30 April 2012.

STATEMENT OF ENVIRONMENTAL EFFECTS: SECTION 75W APPLICATION, MODIFICATIONS TO MAJOR PROJECT MP NO.10_0158 (BUILDINGS 7 AND 8) – 61 MOBBS LANE, EPPING

Title Building 7 Level 1 to Roof Plan

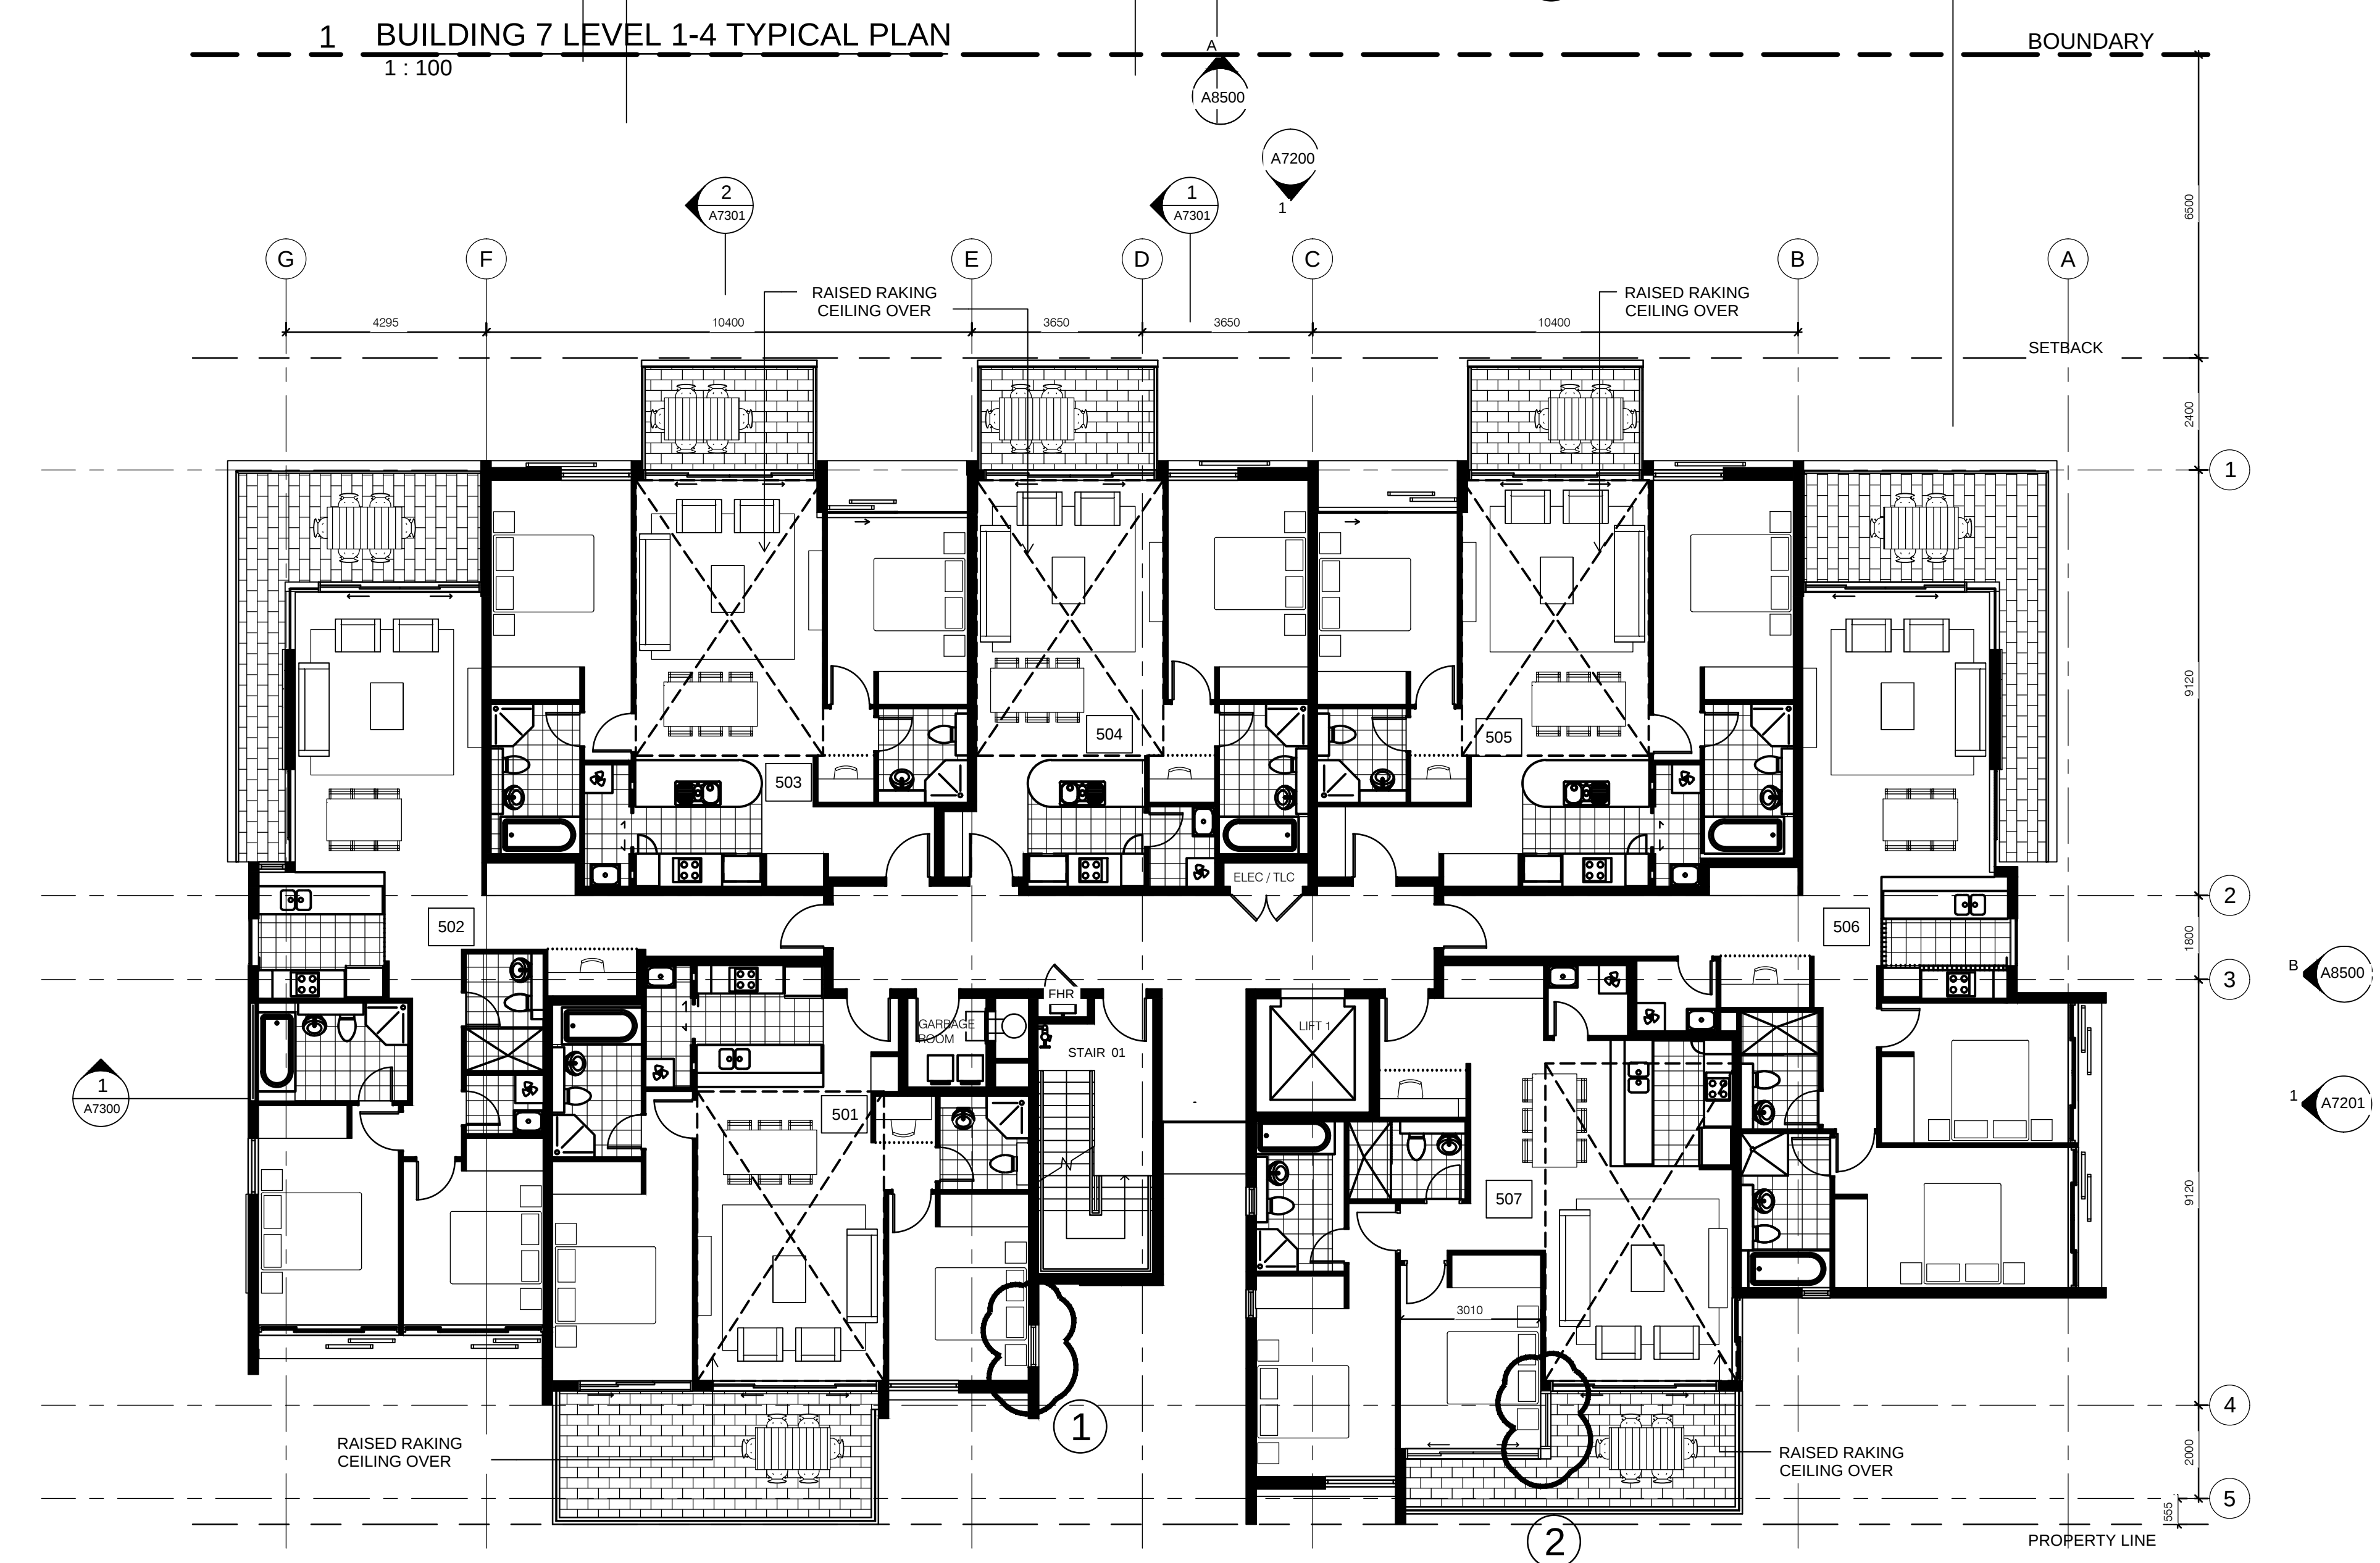
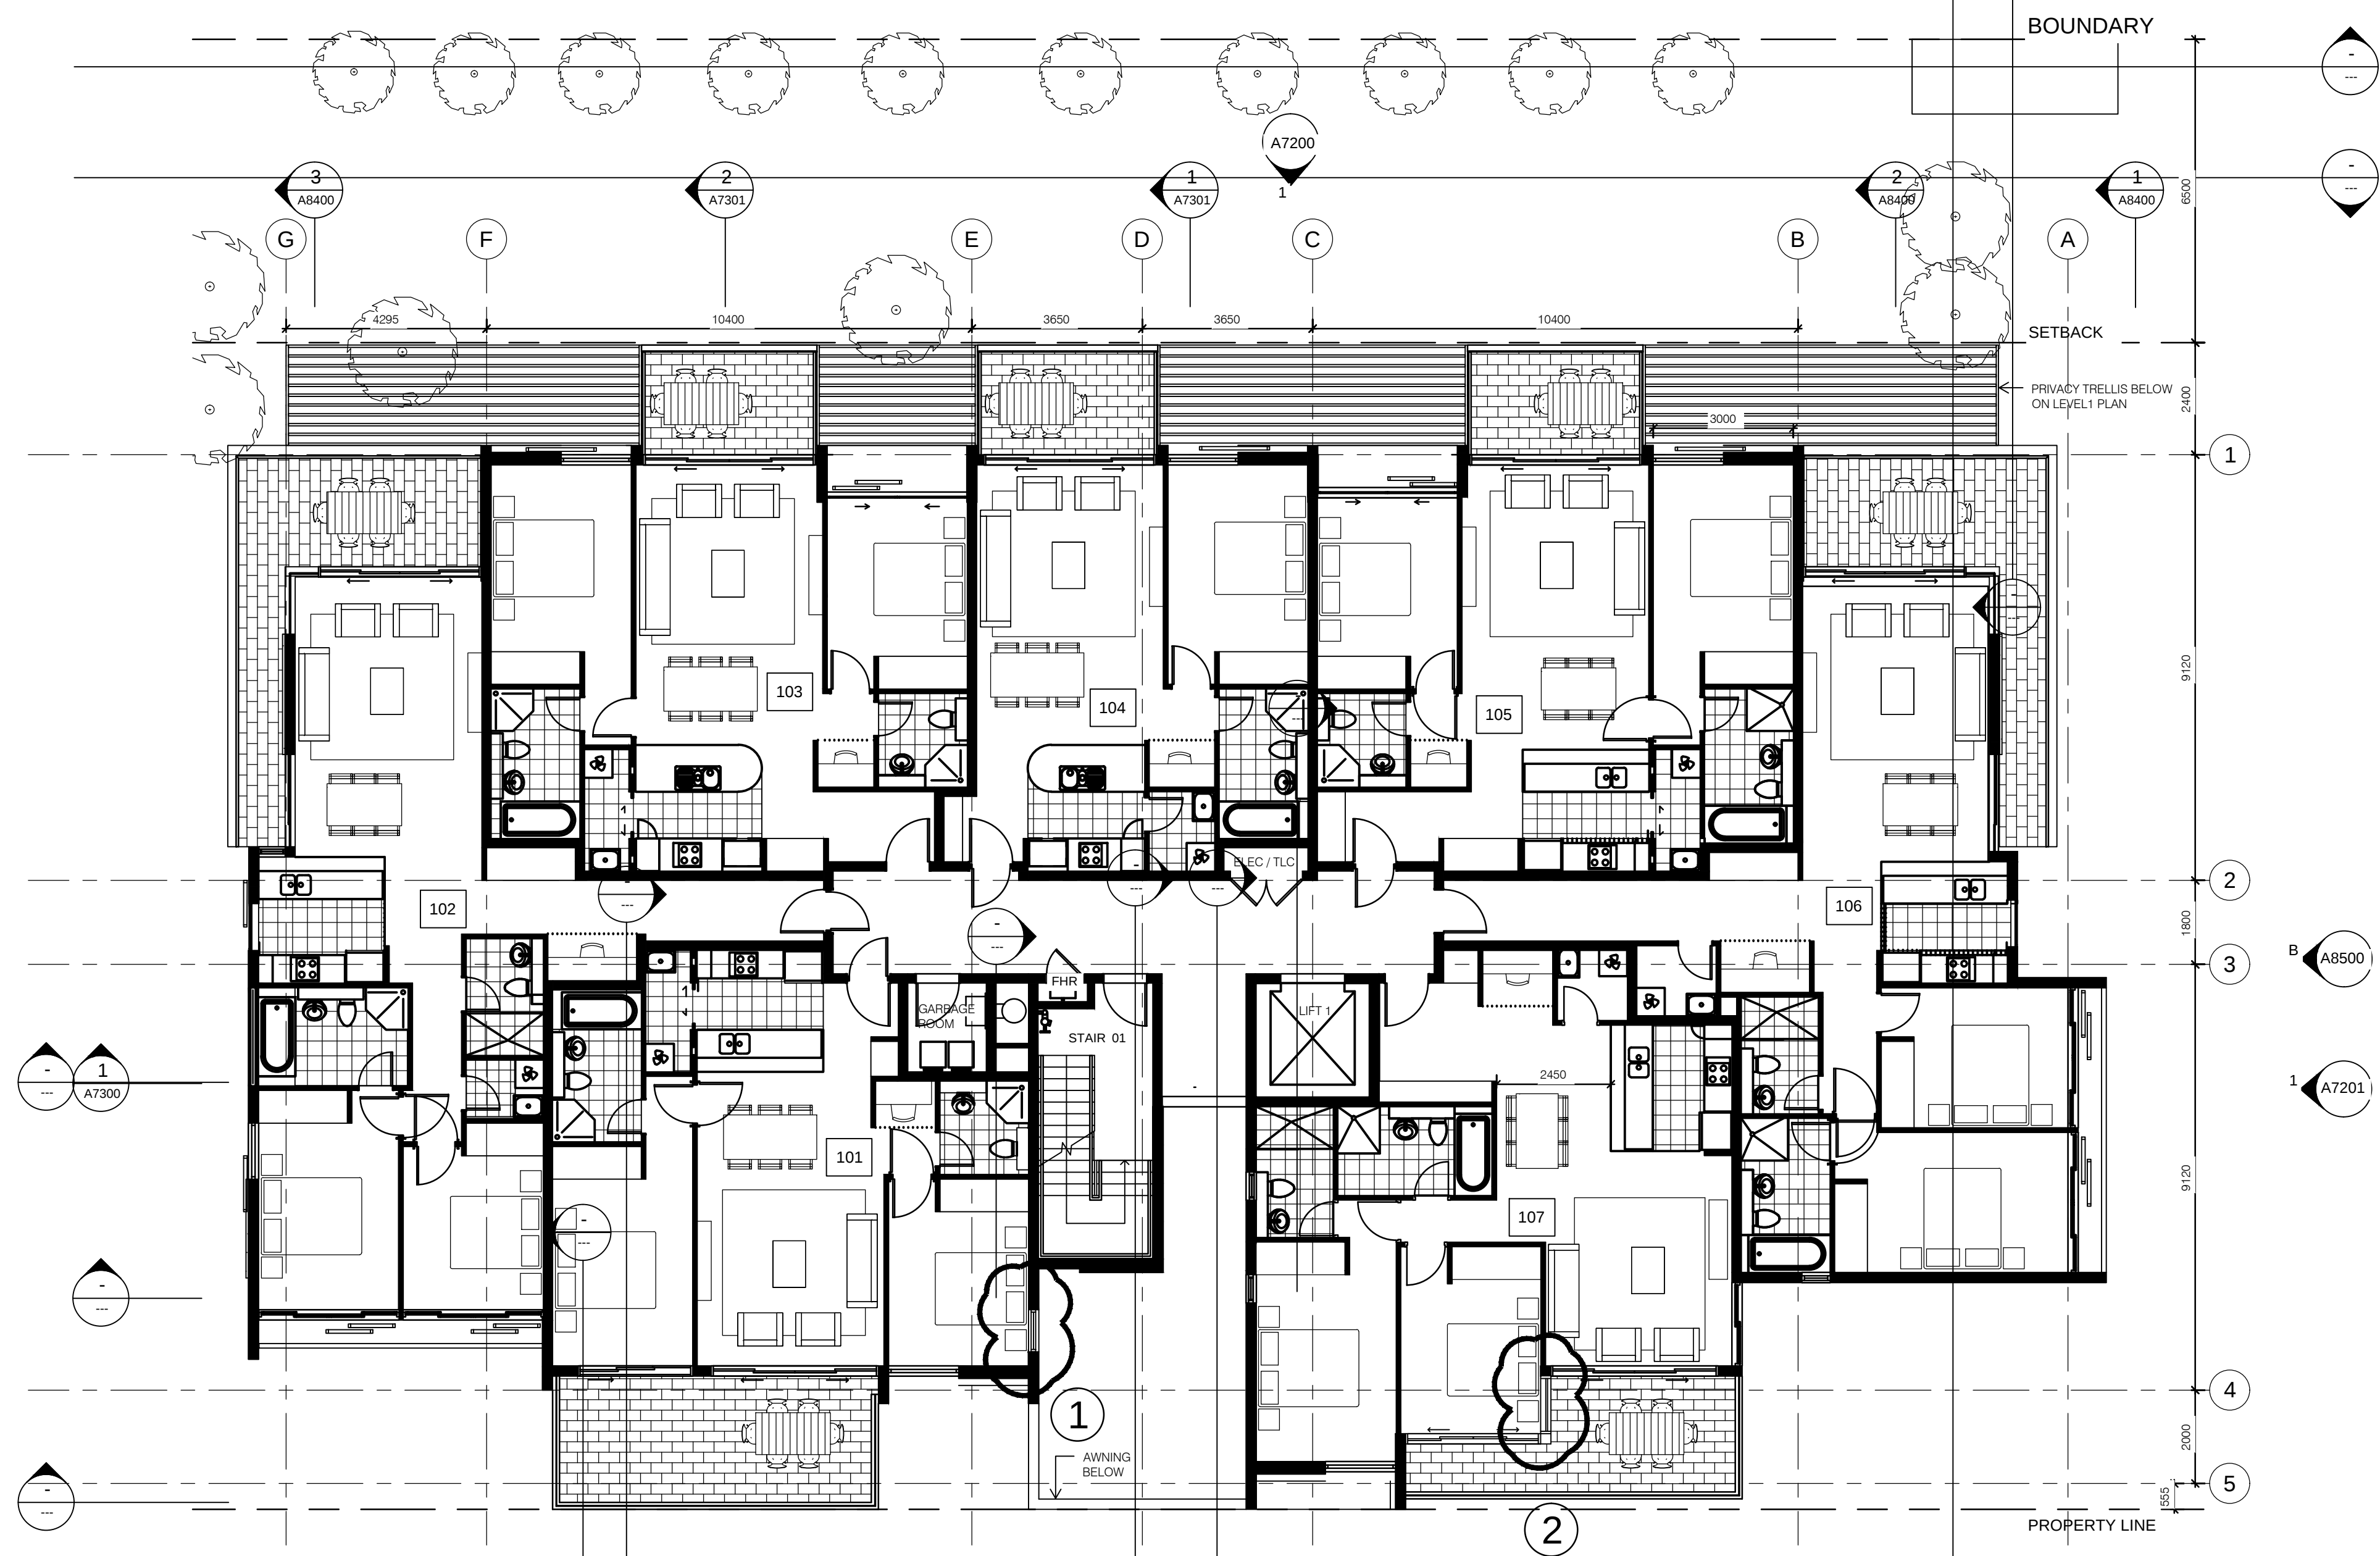
A number of windows need to be relocated for structural reasons. The windows need to be moved along the same wall and at the same height. There is no other change to the size of the window, it is the same window, just re-positioned.

In Building 7 Units 101, 201, 301, 401, 501 are affected by the window repositioning.

Portions of the wall have been replaced with glass to create an architectural feature and more importantly to allow more light into the living rooms. The glazing modifications are identified as number 2, on the Architectural Plan key.

In Building 7 Units G07, 107, 207, 307, 407 and 507. The impact of which is shown on the East Elevation of Building 7. There are no modifications of this nature applicable to Building 8.
